WEST SUSSEX COUNTY COUNCIL CONSULTATION

TO:	Arun District Council FAO: Zac Denton
FROM:	WSCC - Highways Authority
DATE:	8 September 2020
LOCATION:	31 Albert Road, Rustington, BN16 3JT
SUBJECT:	R/156/20/PL Extension and alteration of existing residential dwelling and subdivision to form 2no. two bedroom residential dwellings, together with formation of new vehicular access and entrance drive.
DATE OF SITE VISIT:	N/A
RECOMMENDATION:	Advice
S106 CONTRIBUTION TOTAL:	N/A

DWG NO	984/05	REV. A
---------------	--------	---------------

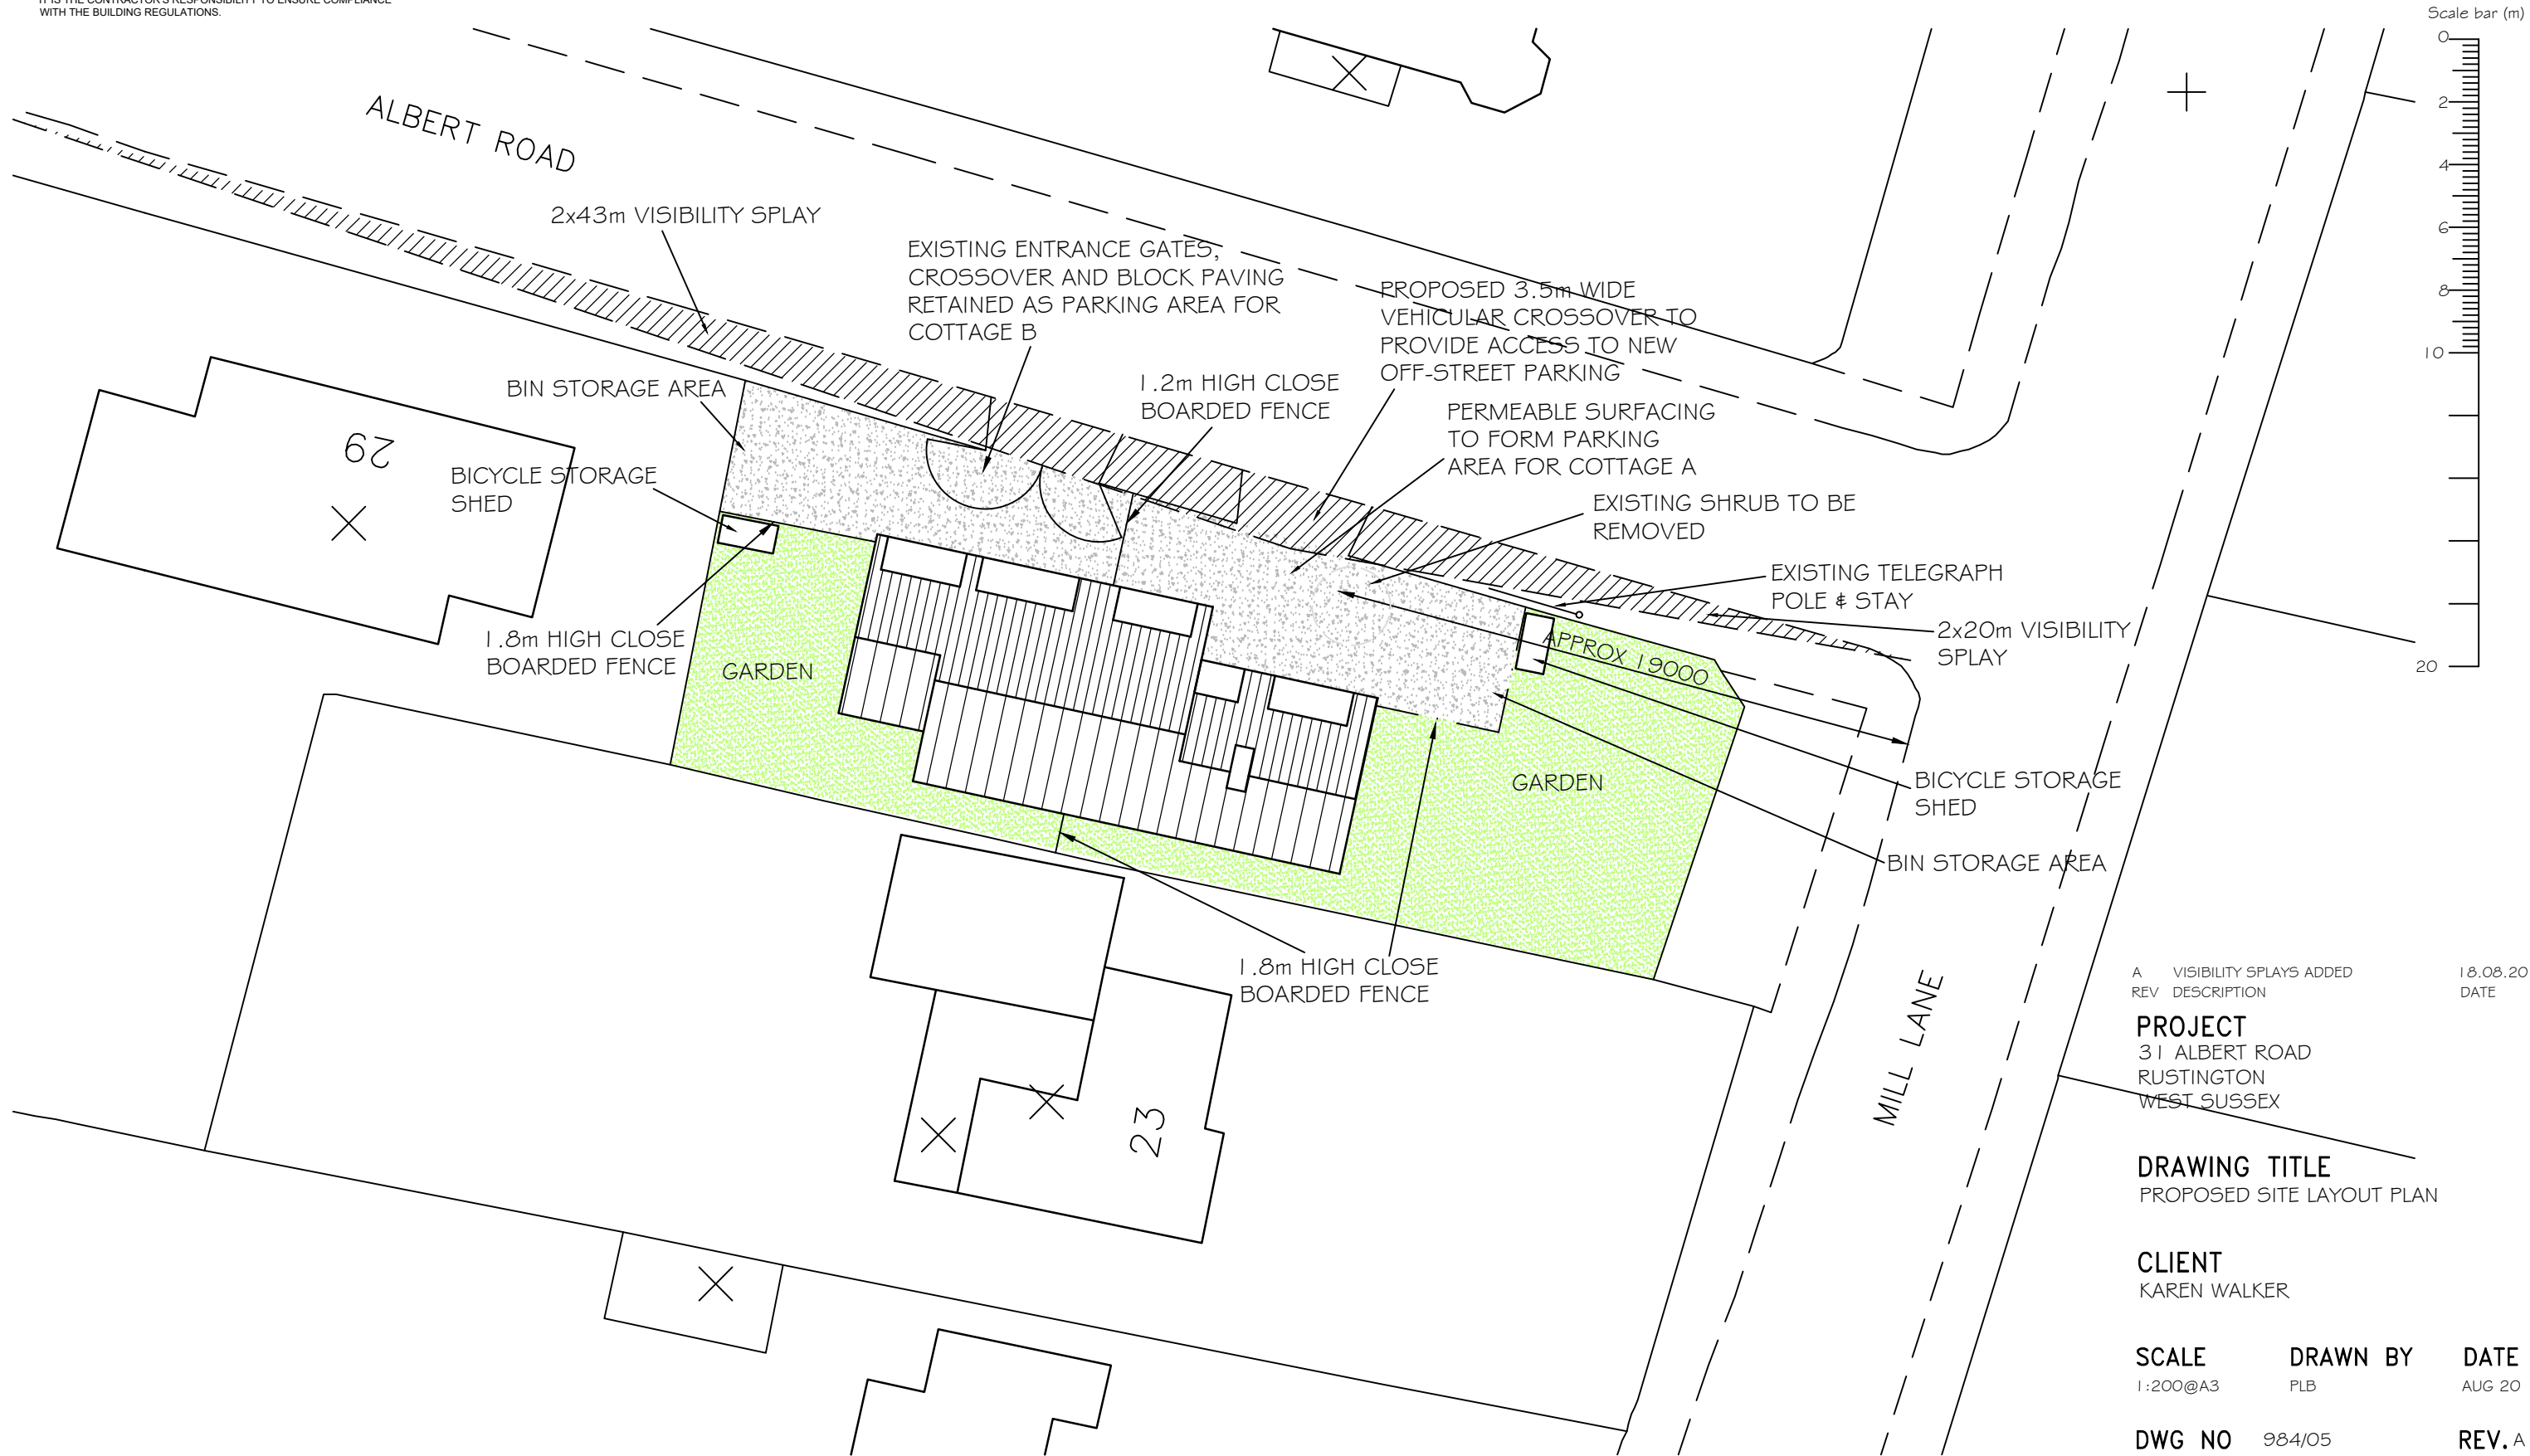
The applicant proposes to utilise the existing vehicular access for one dwelling and create a new vehicular access for the other dwelling. From inspection of the plans and local mapping, there are no apparent visibility issues at the existing/proposed points of access onto Albert Road. The new access will be subject to a vehicle crossover (VCO) licence obtained through the local area office. The 3.5m wide VCO would be constructed to a specification agreed with the local area engineer.

The applicant proposes one car parking space per dwelling for this development. Under Arun Parking Standards (adopted January 2020), the LHA would anticipate that two parking spaces would be sufficient for a development of this size and location. From inspection of the plans, on-site turning may not be achievable, so vehicles may have to exit the site in a reverse gear. The LHA does not anticipate that this would give rise to any adverse impacts on the maintained highway.

No part of the development shall be first occupied until such time as the vehicular access serving the development has been constructed in accordance with the details shown on the drawing titled "Proposed Site Layout Plan" and numbered "984/05 (Rev. A)".
